Our Ref: K/1/12/

7th February 2012

Side extension to provide garage and store (re-application following K/25/11)
29 Golden Avenue East Preston

DRAWING TITLE
EXISTING FLOOR PLANS

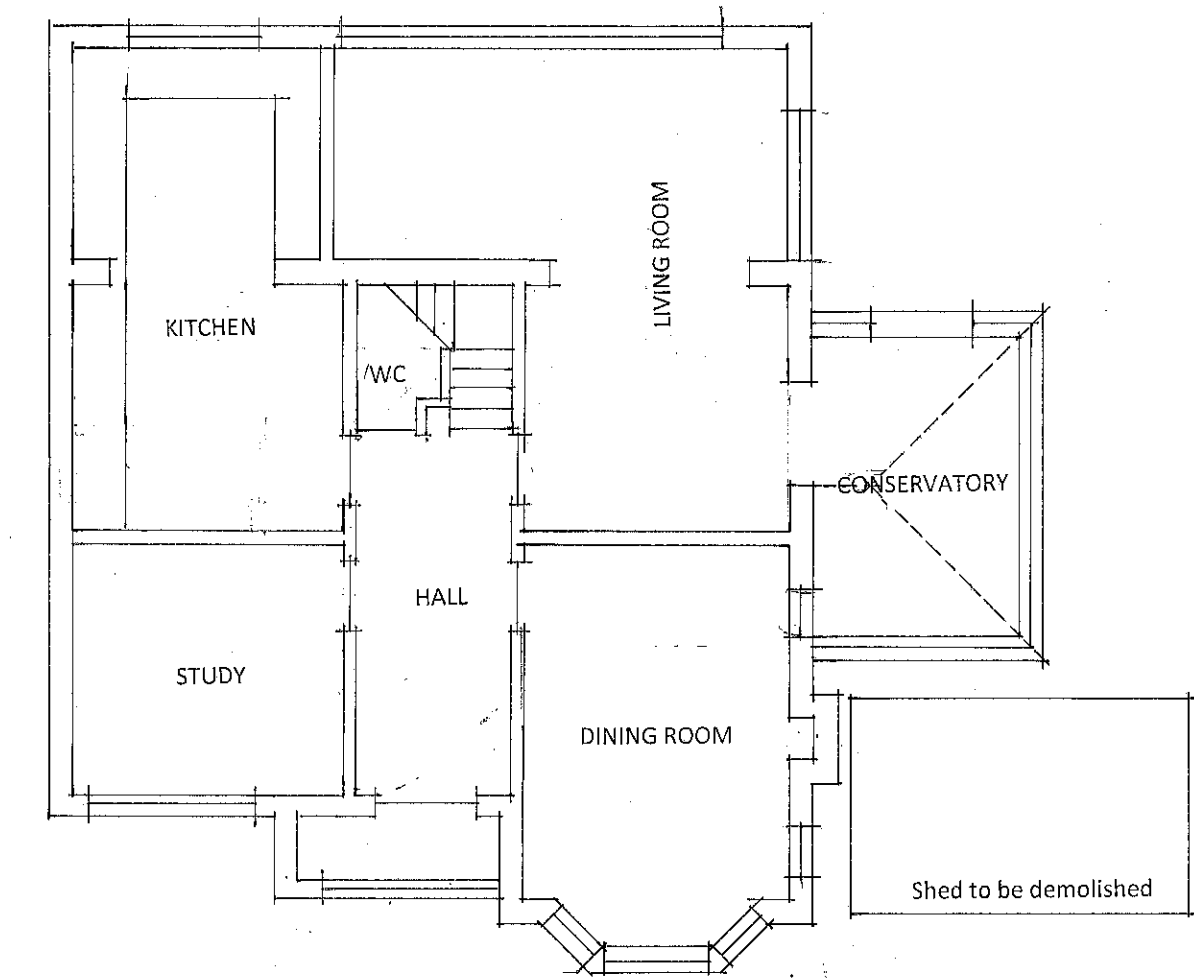
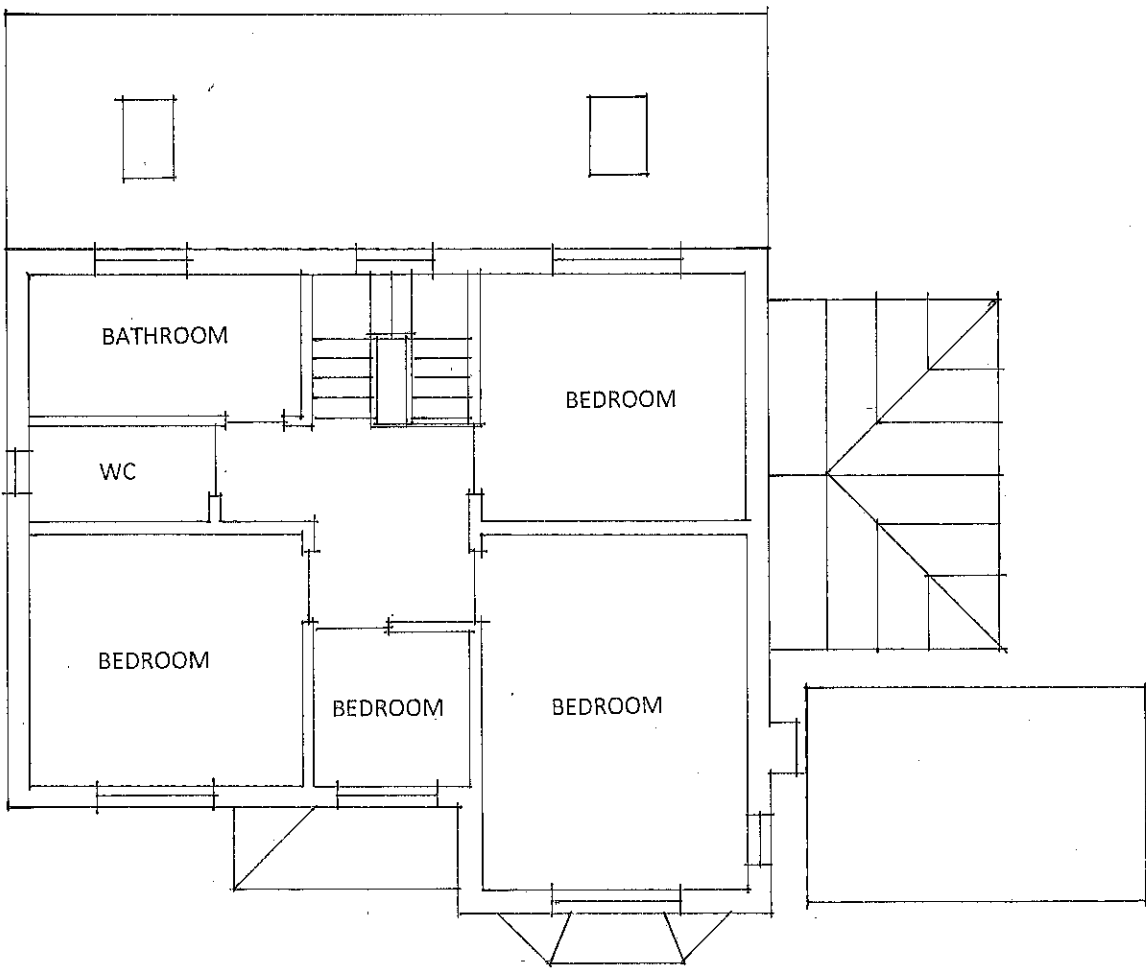
Both the existing and proposed North first floor plans do not accord with both existing and proposed 1st floor elevation. Please amend accordingly.

EXISTING ELEVATIONS SHEET 2

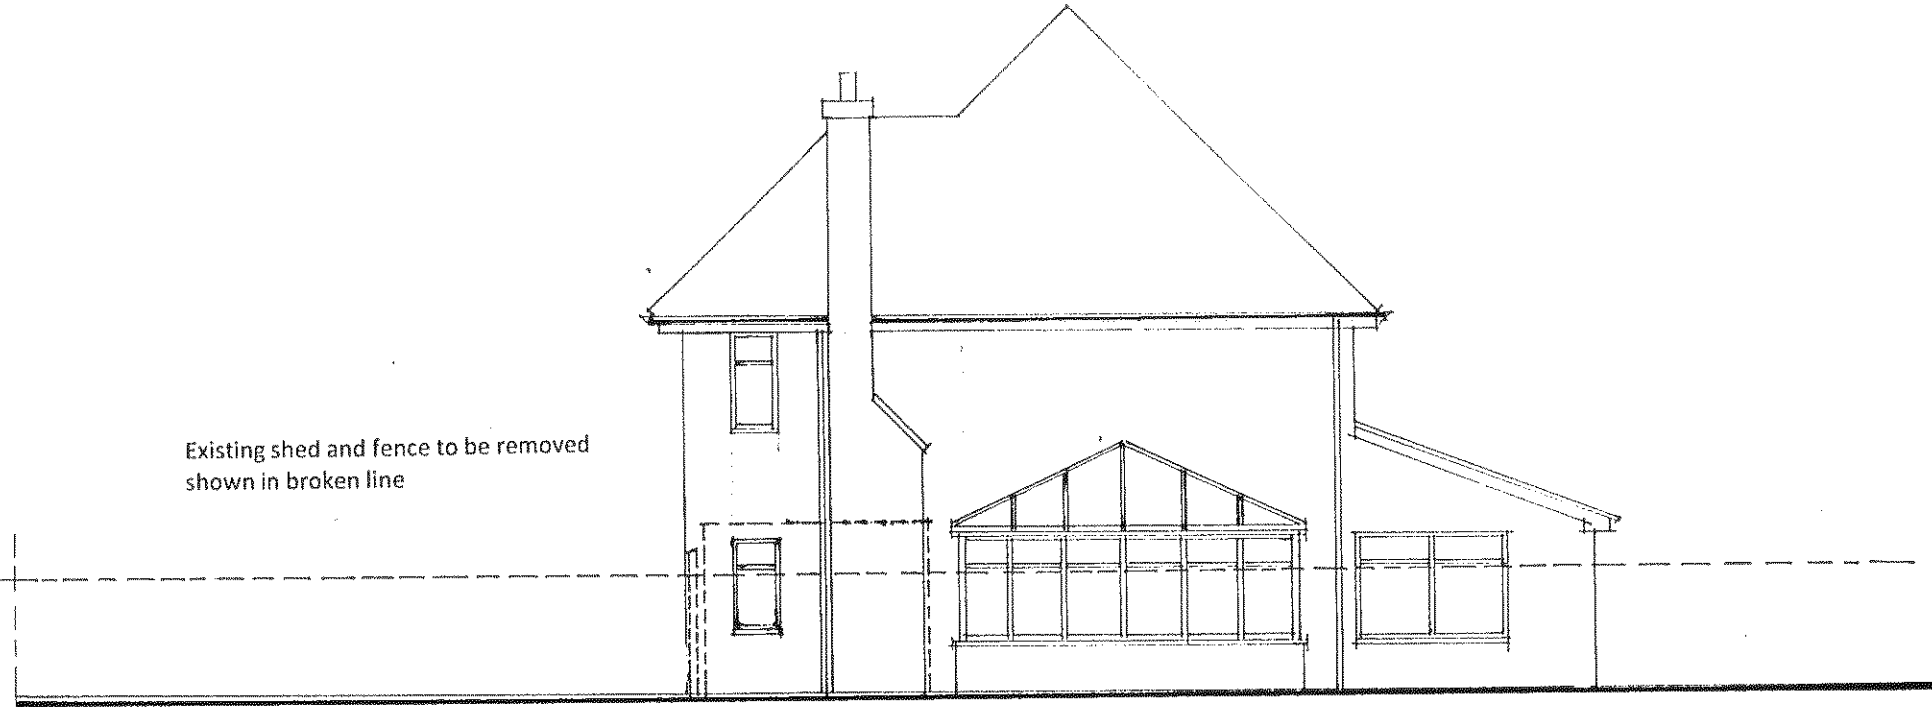
The rear garden elevations and East elevations have been labelled incorrectly on both the existing and proposed plans. Please amend accordingly.
